An
Bord
Pleanála

Inspector's Report ABP-318816-24.

Development	10 year permission for 8 no. wind turbines and associated works
Location	Cush, Co. Offaly.
Planning Authority	Offaly County Council.
Applicant	Cush Wind Limited
Type of Application	Section 37E of the Planning and Development Act 2000, as amended.
Statutory Consultees	Offaly County Council Transport Infrastructure Ireland DAU (Department of Housing, Local Government and Heritage).
Observer(s)	Agnes Doolan, Una Watkins, Patrick and Kathleen Watkins, Patrick and Padraic Watkins, Catherine and Edel Watkins, Abina Guinan, Liam and Michelle Guinnan, Theresa Watkins
Date of Site Inspection	12 th September 2024
Inspector	Philip Davis.

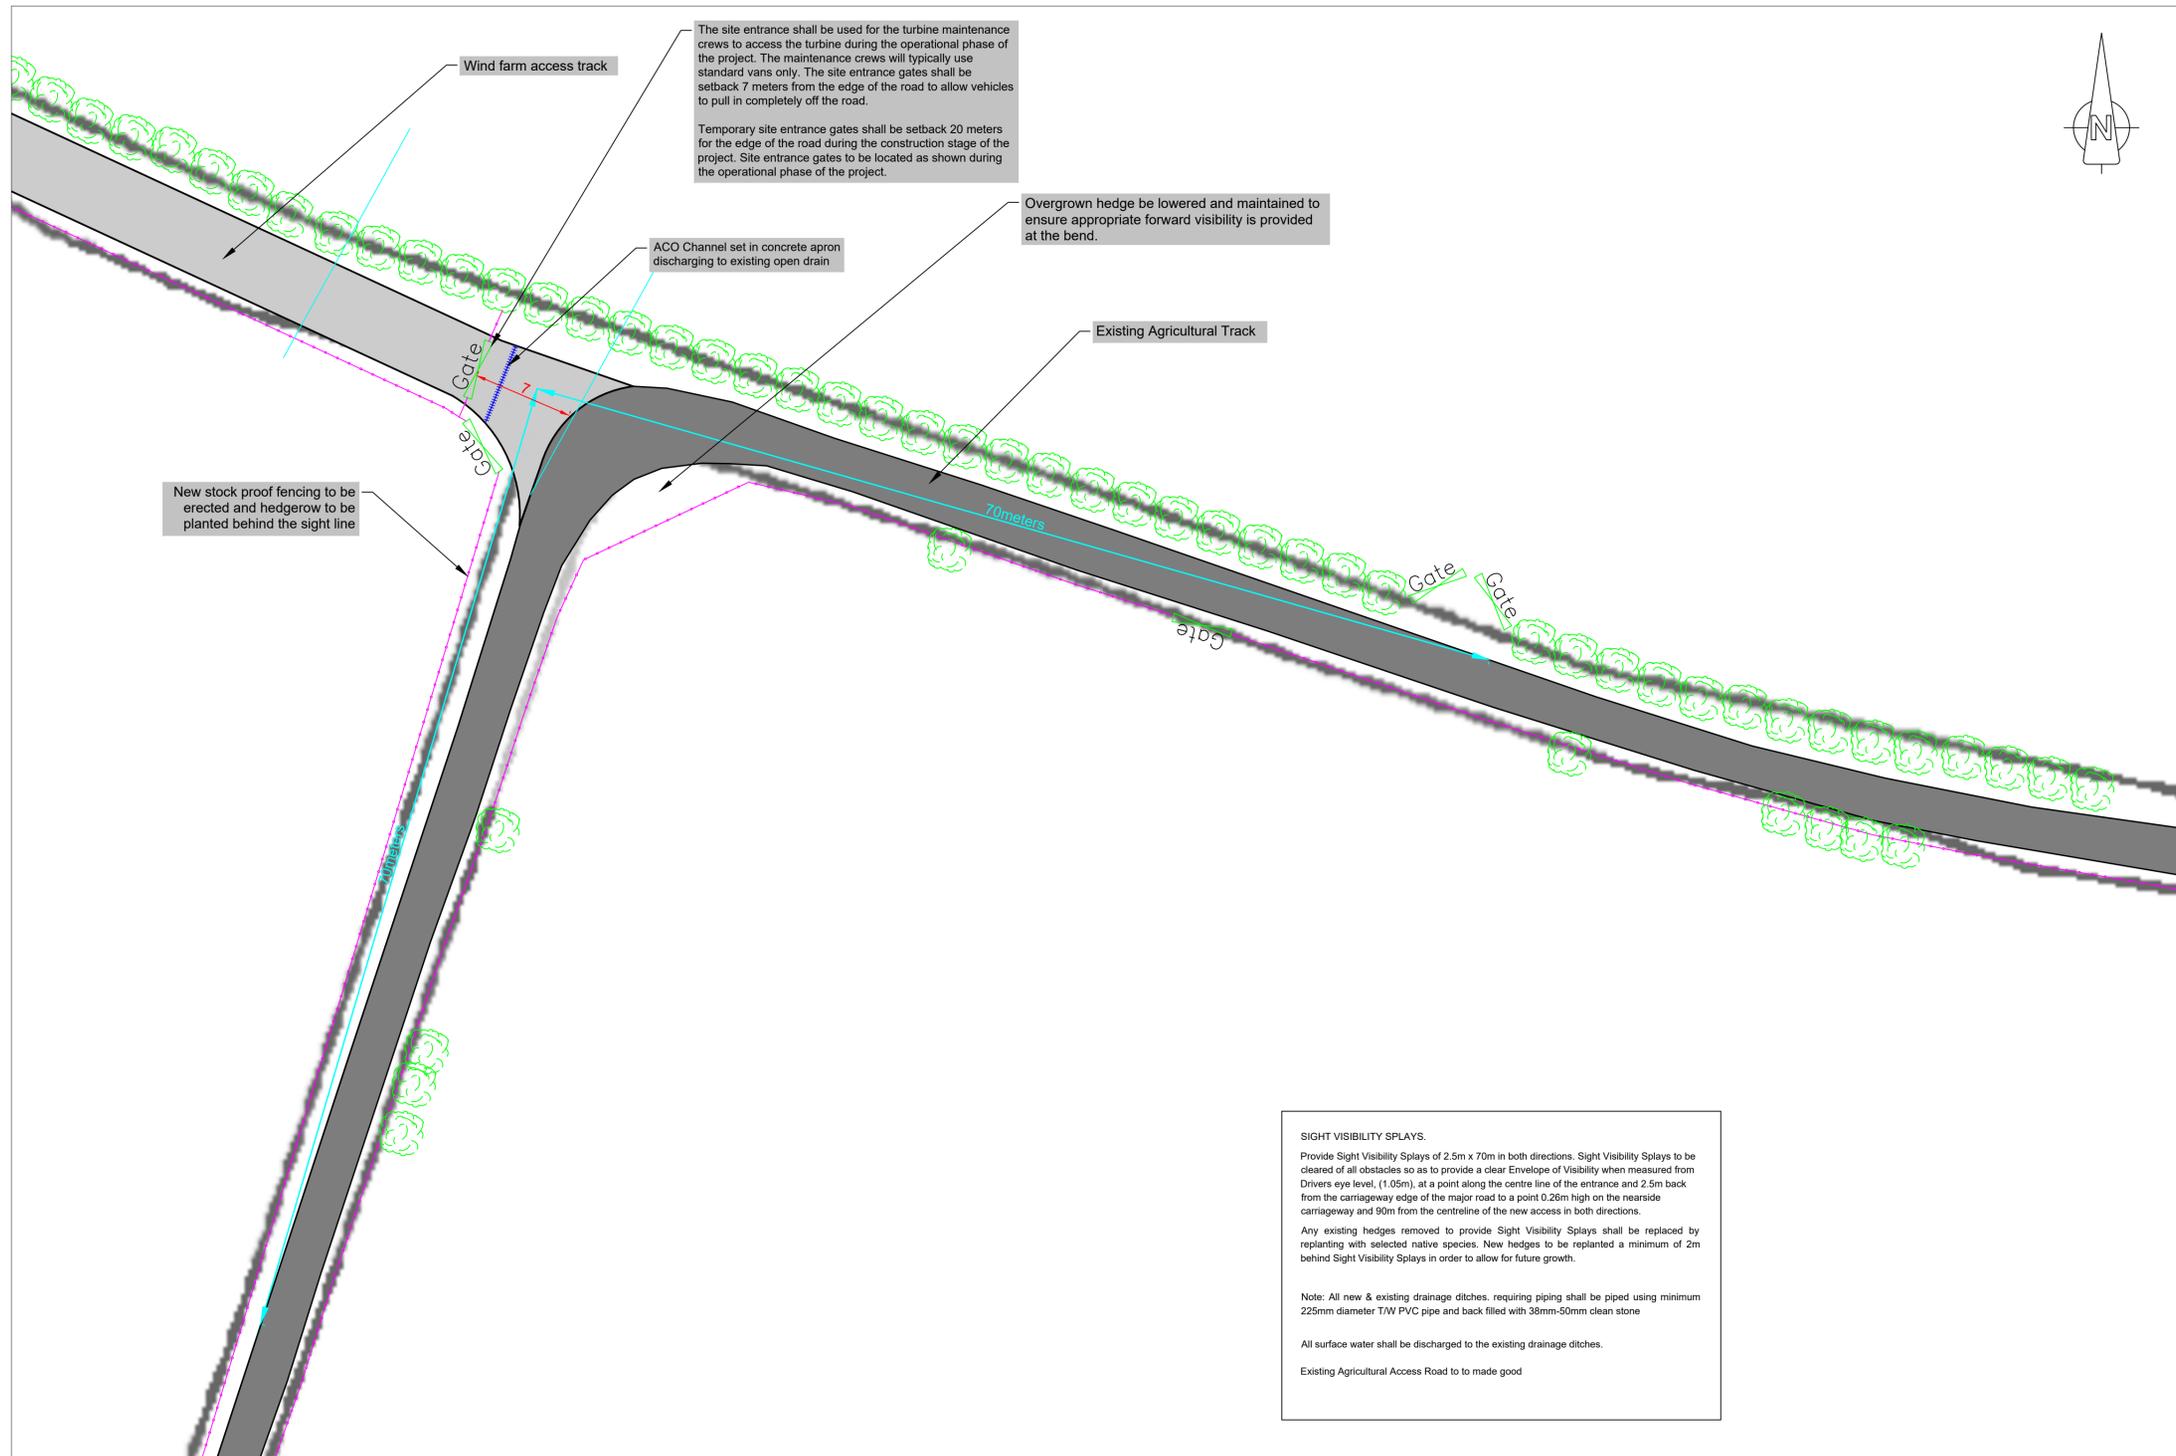
- Highlights a number of protected structures which appear to have been overlooked.
- Notes need to restore proposed temporary turning head at Kennedy's crossroad (N62/N52 junction).

- It is considered that the application is only acceptable if there is a clear commitment that the temporary construction entrances are completely removed after construction finishes if they are the national road and within the 100kph zone.
- TII is not satisfied that the proposed works at the junction of the N52 and N62 has had regard to TII compliance requirements, and it is not considered that the proposed mitigation measures are adequate for safety.
- It is noted that there is a lack of clarity on the method to be used for the cable crossing of the N62. It is considered that only the use of horizontal directional drilling is appropriate.
- It is noted that it is intended to provide a haul route from Galway Harbour for oversized turbine loads. It is considered that there is insufficient information in the submission for alternative routes.

- Additional information on temporary and permanent works required to accommodate the proposed temporary construction accesses off the N62 and the temporary turning head at the N52/N62 junction.
- Additional information required on the proposed cable crossing of the N62.
- Revised documentation and plans required to address the delivery haul route for oversized loads.
- The above to be reflected in an updated EIAR in line with published TII guidance.
